From: Maria Tomalova
Sent: 03 August 2022 12:14
To: Planning.Responses
Subject: FW: P/59/22/L - Pennicotts Farm - Email 1 of 3
Attachments: 0971 - Window Schedule - V3.pdf; 971 - Pennicotts Farm - Issue 27 1-4 ListedBuilding Amenity Treatment copy.pdf

P/59/22/L

Pennicotts Farm Pagham Road Pagham PO20 1LN

Listed Building consent for works associated with refurbishment of property pursuant to Listed Building Consent reference P/123/20L for the demolition of existing conservatory to southern side of building & general repair & maintenance of external brickwork & roof coverings, replacement windows etc. Internal alterations comprising the removal of partition walls, reinstatement of wooden balustrade to staircase, and general repair, maintenance and refurbishment.

Window Detail 1:5

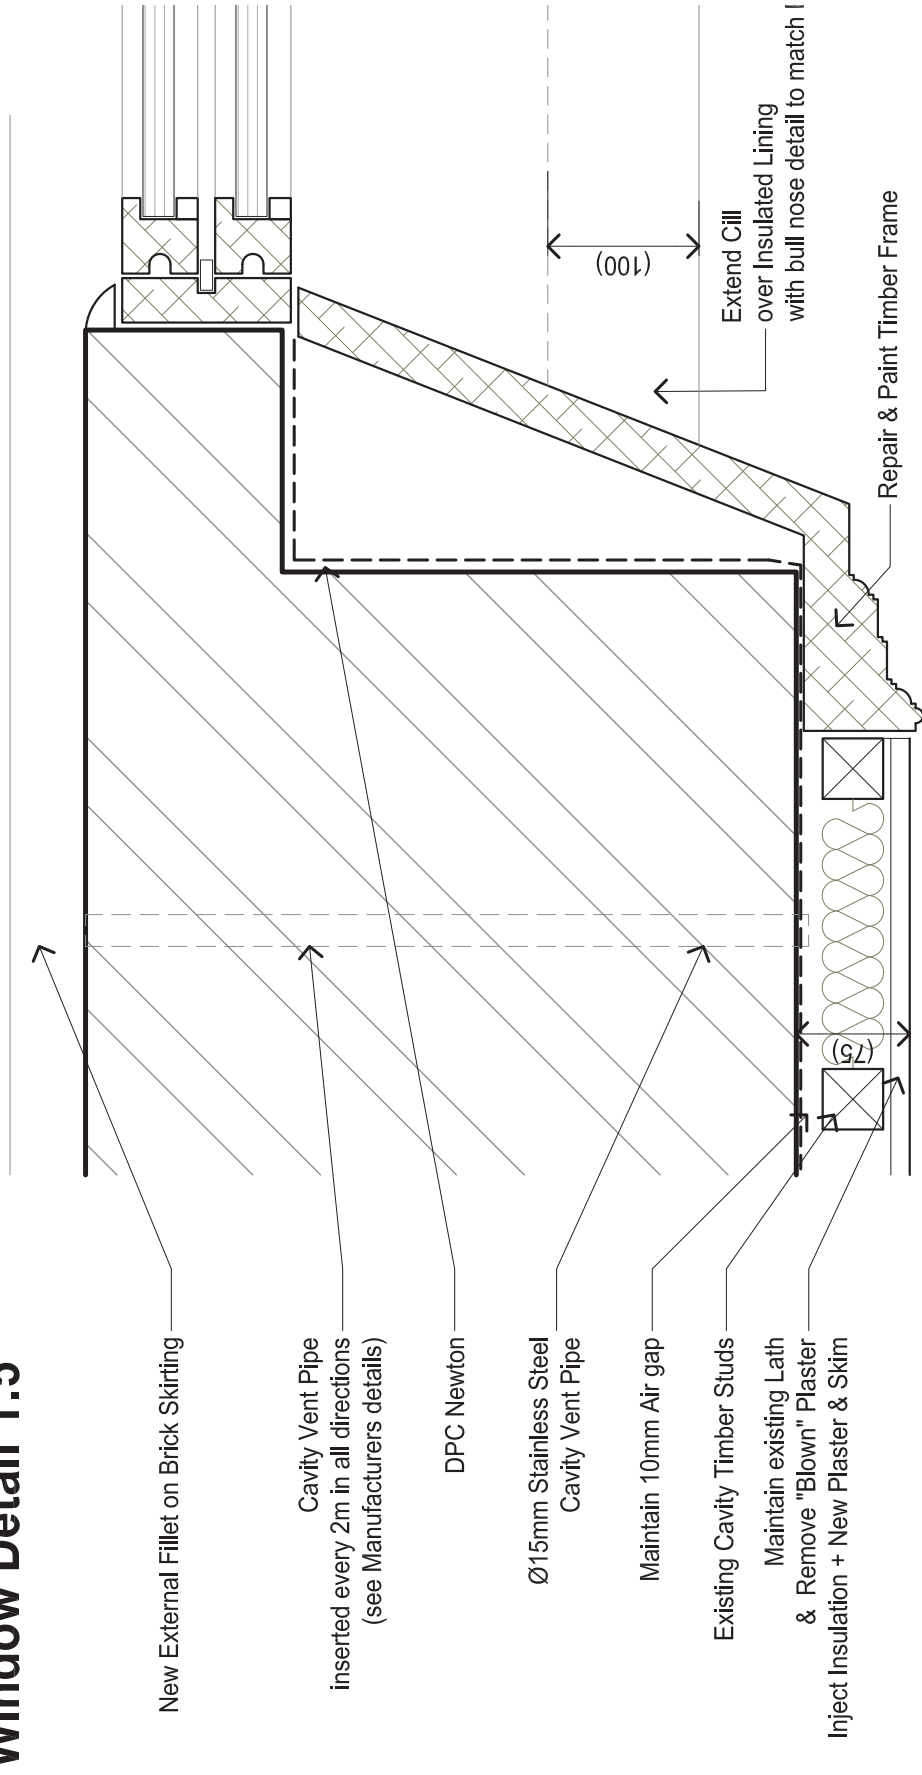
Windows are an important feature within a listed building, and their replacement should be carefully considered. Good practice is that existing windows should be retained and repaired prior to their wholesale replacement. As previously noted, whilst double glazing could be accepted, they should be of the slimmer units, as opposed to the standard ones. It is clear from looking at the plans (Window details DWG No971-B891 Rev E) that the double-glazed units will be of a standard design (such as 24-28mm), as opposed to the slimmer design (such as 12-14mm). As previously identified, the use of the standard design, and measurements will not be supported. However, I also note in the Heritage Statement in paragraph 4.3 that it states, “Notably the replacement windows are of a heritage style design with 12-14mm units, thereby addressing the previous reason for refusal”. If this is the case, then surely the plans should be amended to reflect this! If this is the case, and can be confirmed, the slimmer units can be accepted.

1. The replacement window double glazing will be 12-14mm thick, and this is clarified on the attached revisions to the drawing set.

DT21

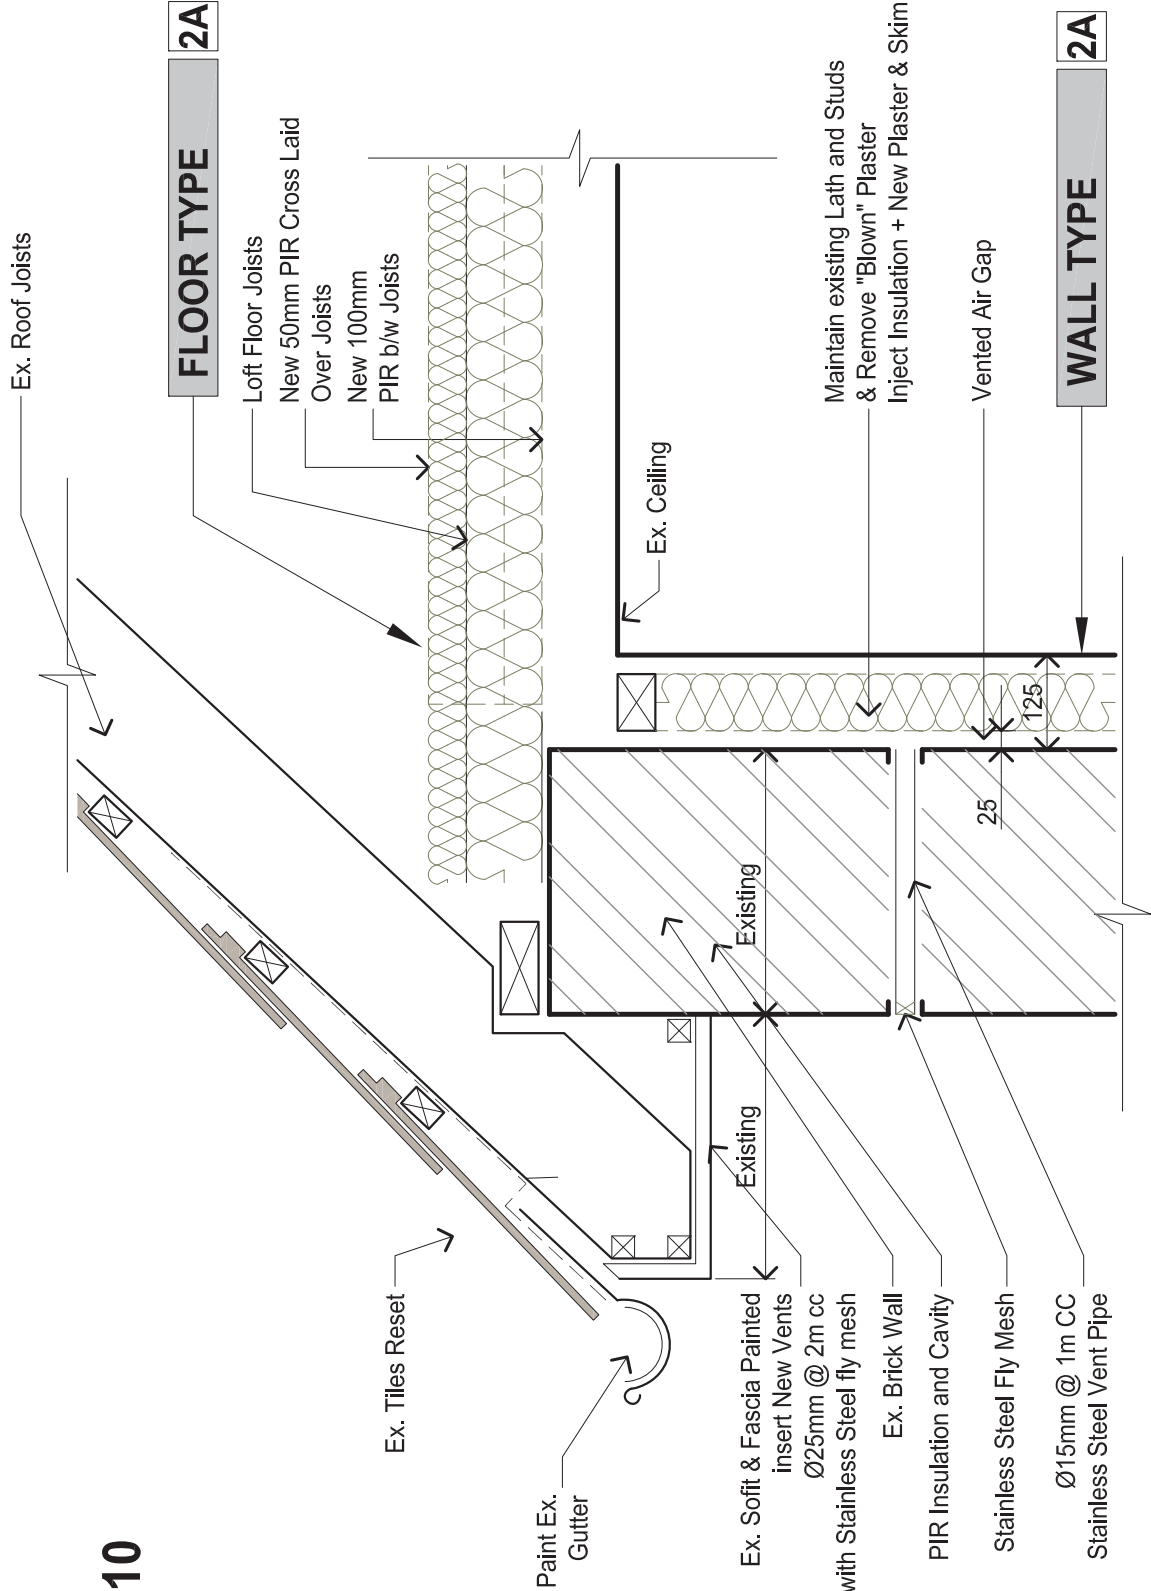
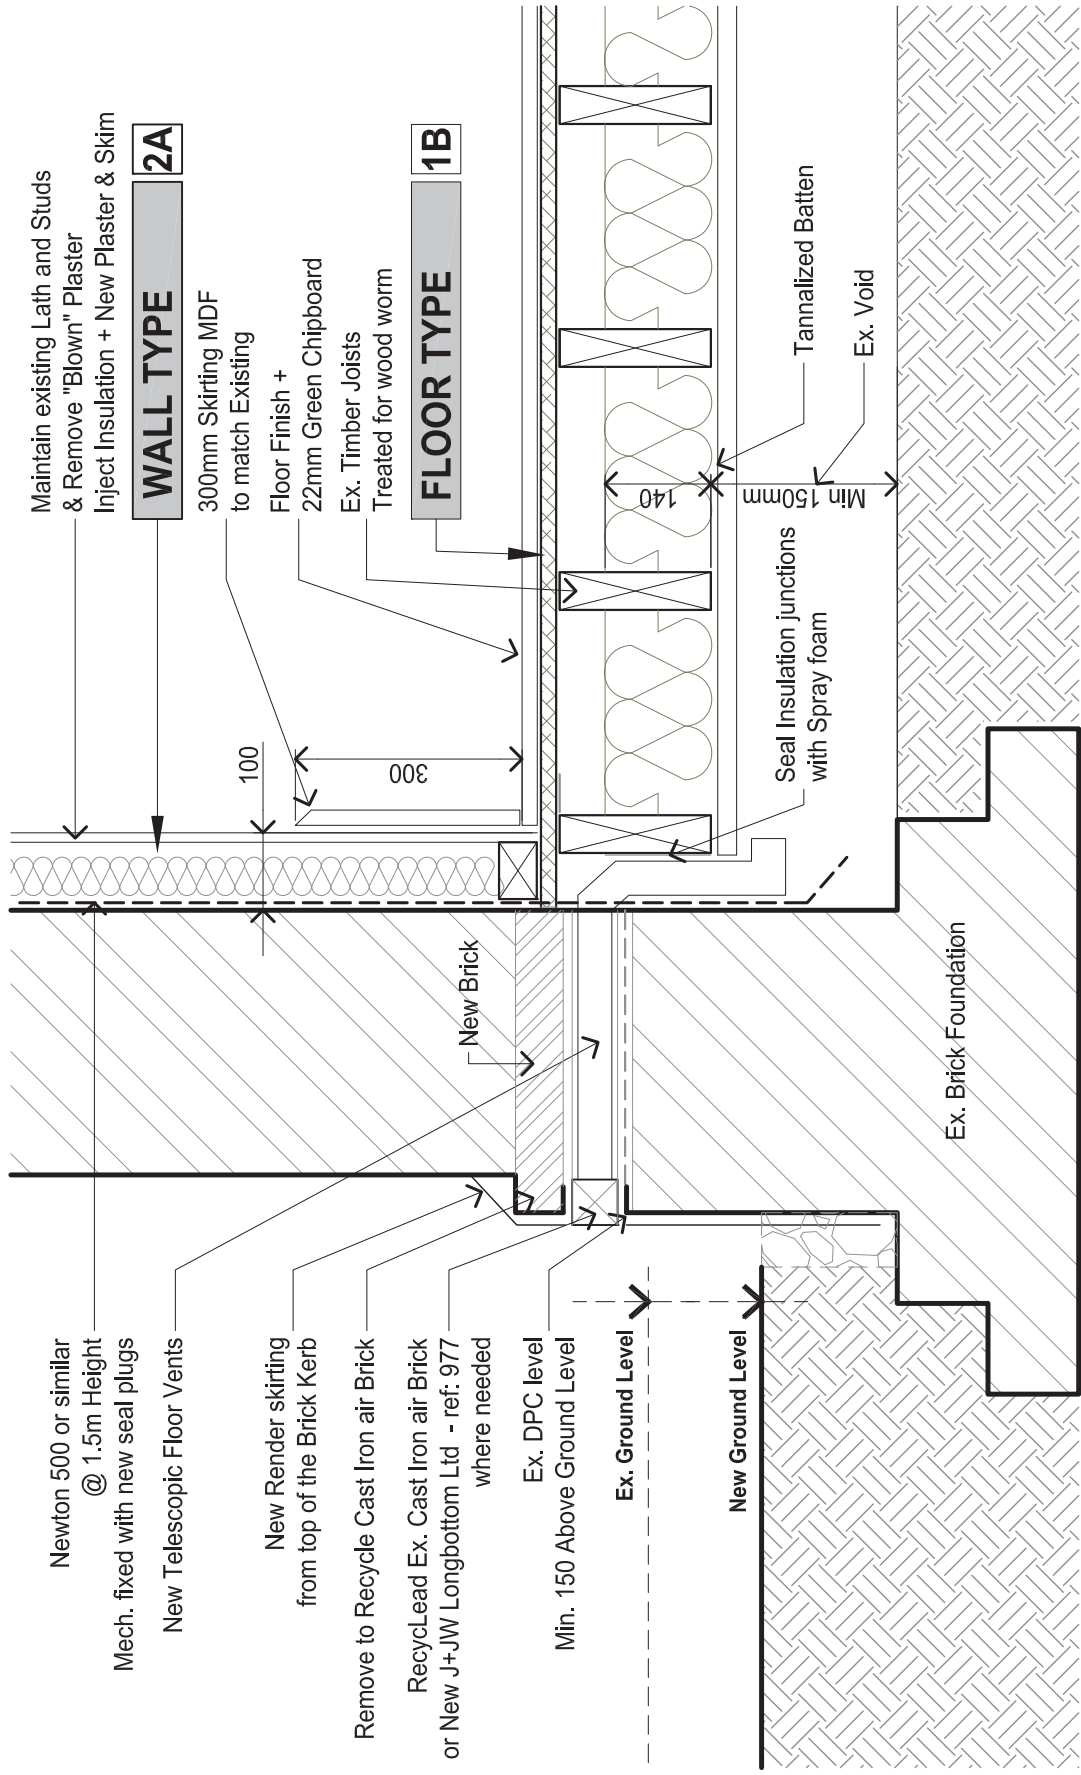
details of the stainless-steel wall vents, which I am unable to locate.

4. Details of wall vents - the position of the proposed wall vents are indicated on Drg. B620, and their detail is provided within the sections DT02 and DT21 of Drg. B900.

971 - B101c

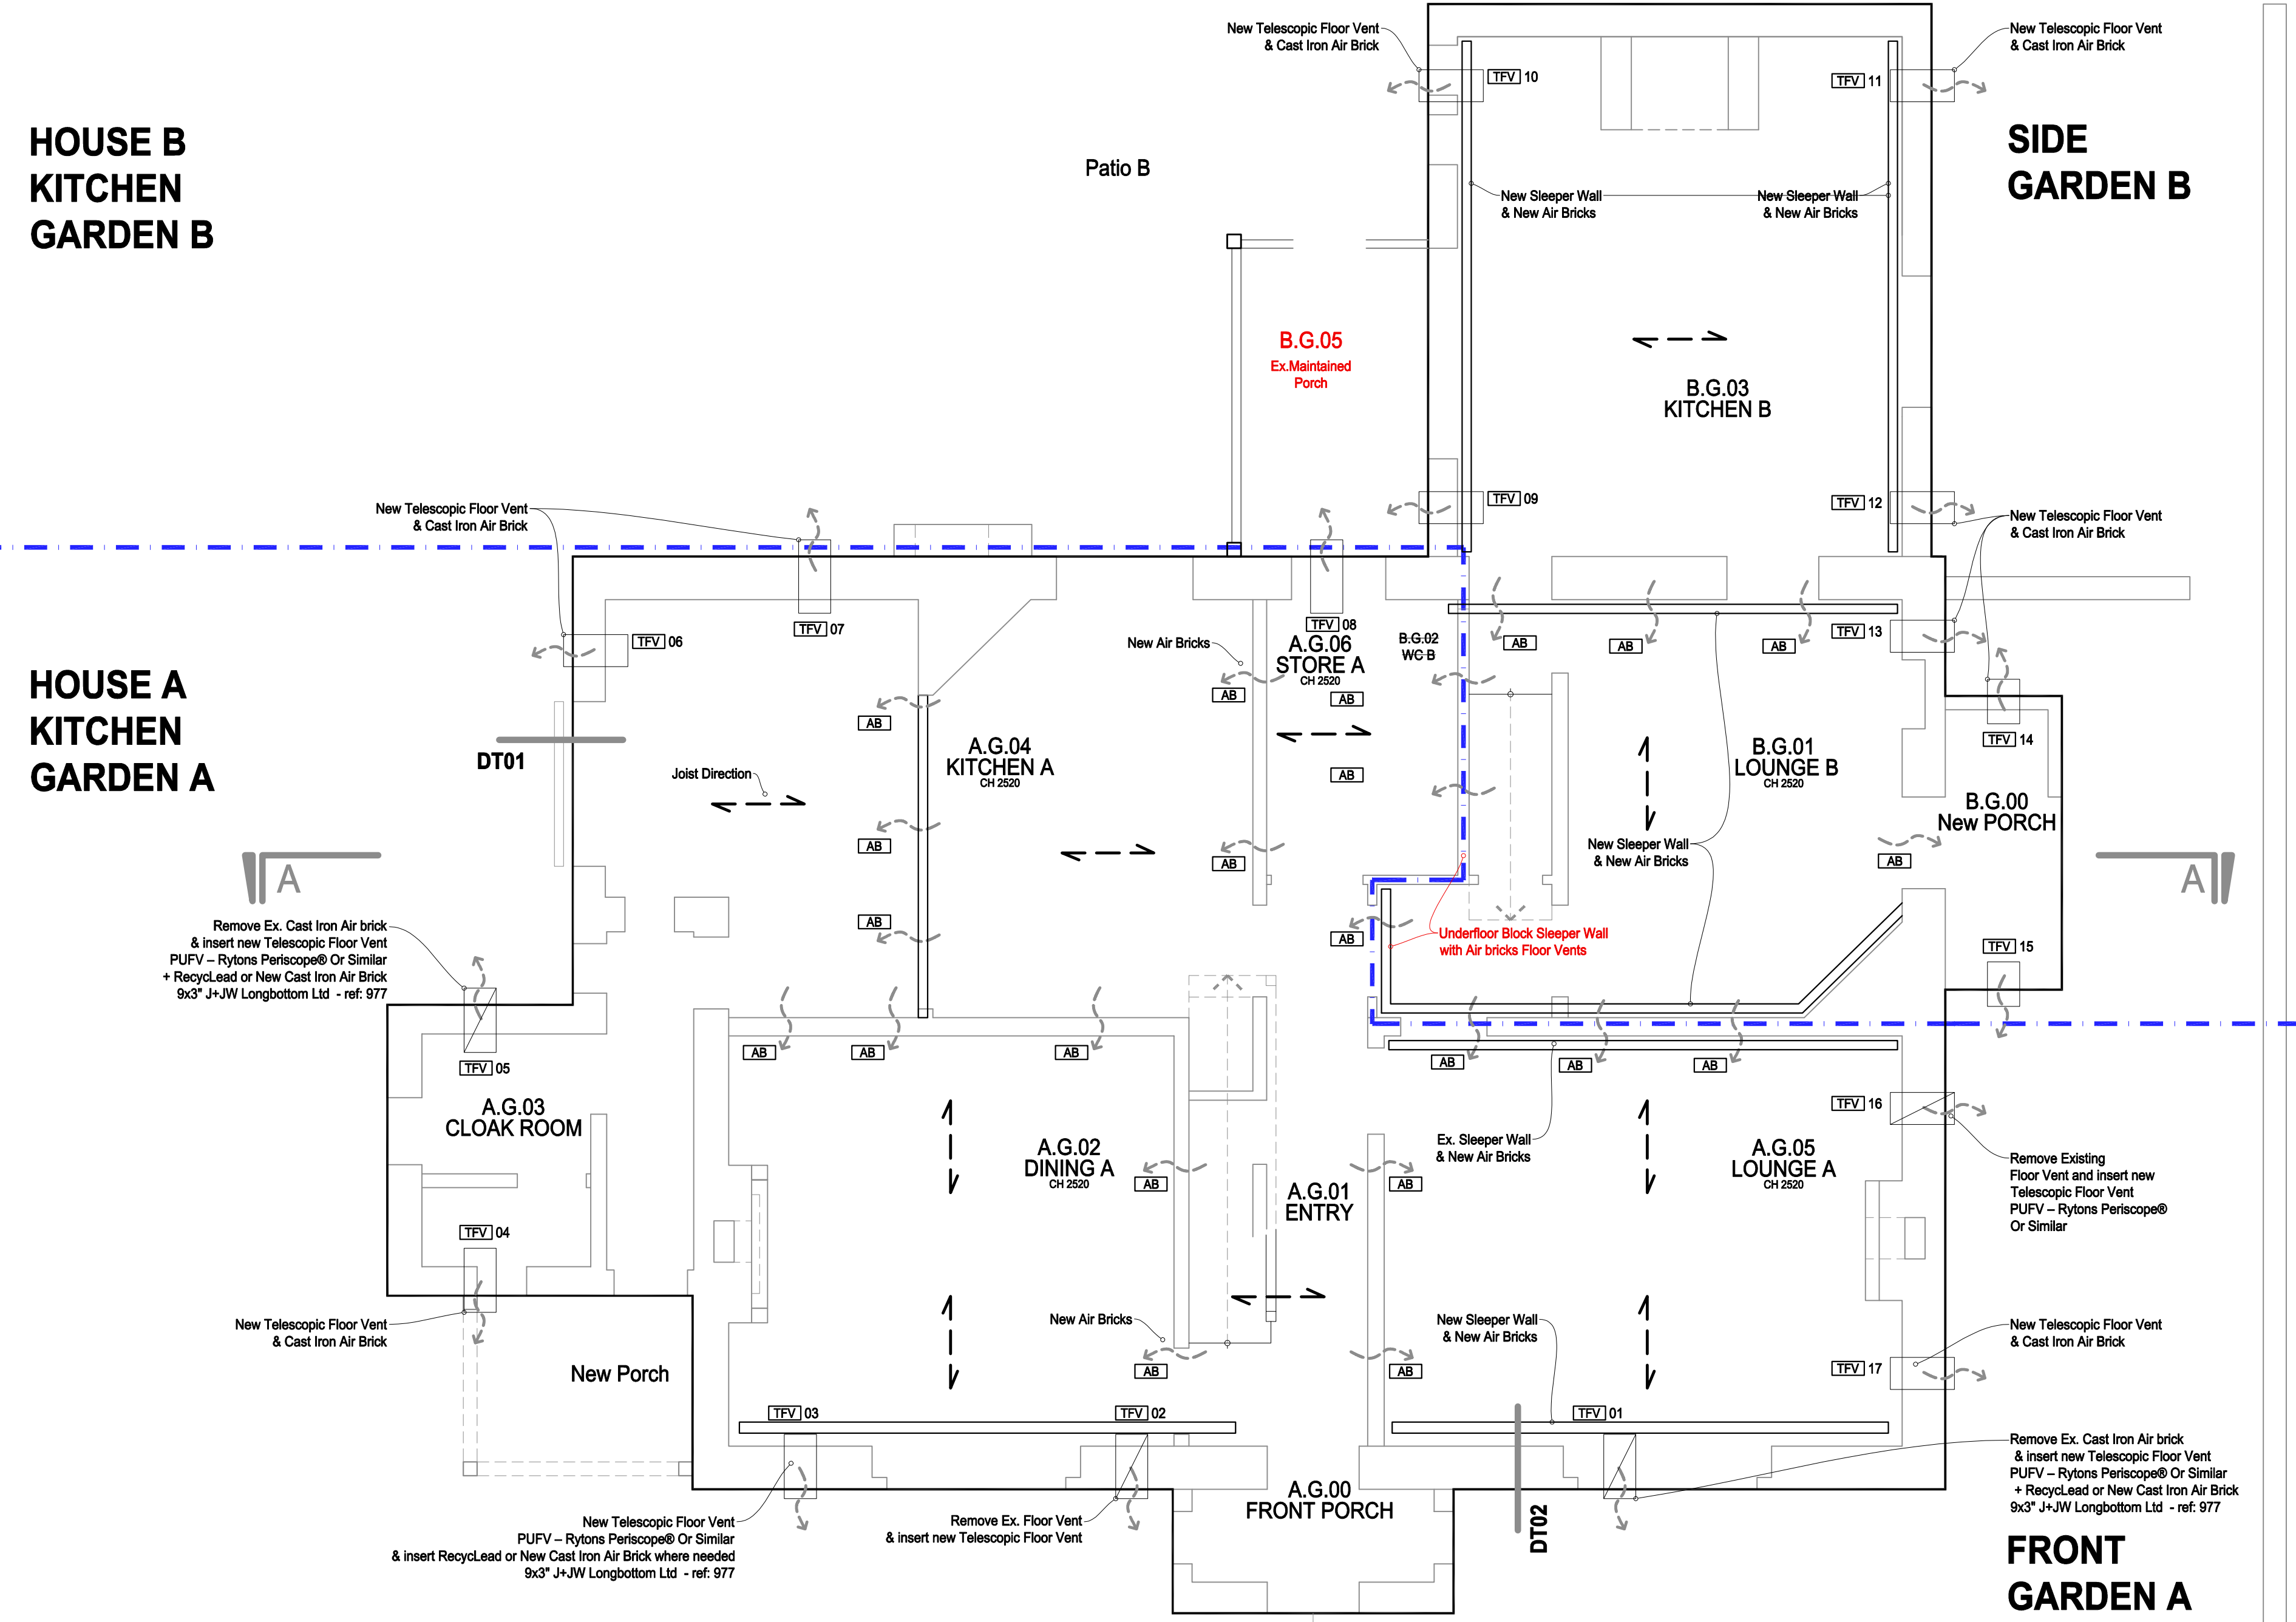
Can it be confirmed if unit B is to have a replacement rear conservatory or new porch? Both references appear on the various plans. For instance, the plan titled 'GF Plan Structures refers to 'new conservatory replace existing', whereas the proposed rear elevation plan refers to 'Garden Porch'.

1. Repointing - The existing Lime mortar will be analysed and lime mortar colour and consistency comparisons will be conducted so as to ensure a perfect match to the existing. To enable an even / equal bed depth, the existing lime mortar will be raked out by traditional manual tool, on a block of wood. No rotating blades or machinery will be used, so as to ensure the bricks are not damaged.
2. Unit B rear garden porch - It is confirmed that the existing porch is to be maintained - as confirmed on the attached revisions to the drawing set.
3. Rainwater goods - The materials and colour of all rainwater goods will be as per the front elevation, i.e. dark grey (RAL 7016), as confirmed on the attached revisions to the drawing set.
